Our Ref: BR/313/11/  
Your Ref:

20th December 2011

**Single storey extension**  
**236 Hawthorn Road Bognor Regis**

Proposed South Elevation

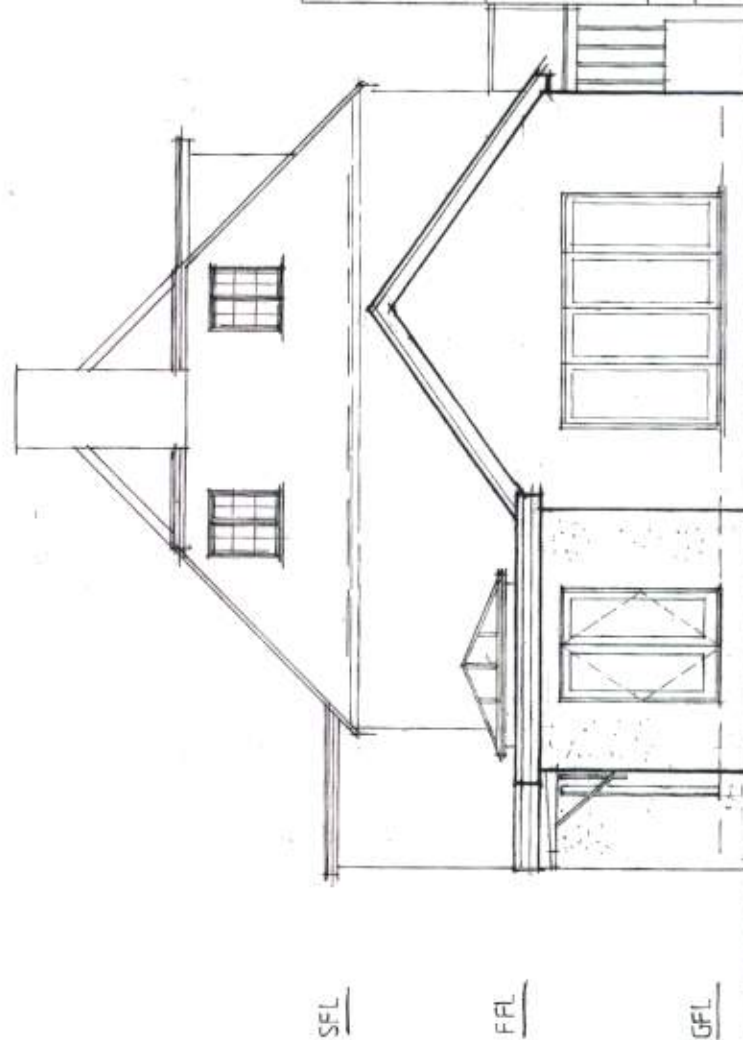
The existing and proposed South elevations do not accord with the existing and proposed South floor plans. Please amend accordingly.
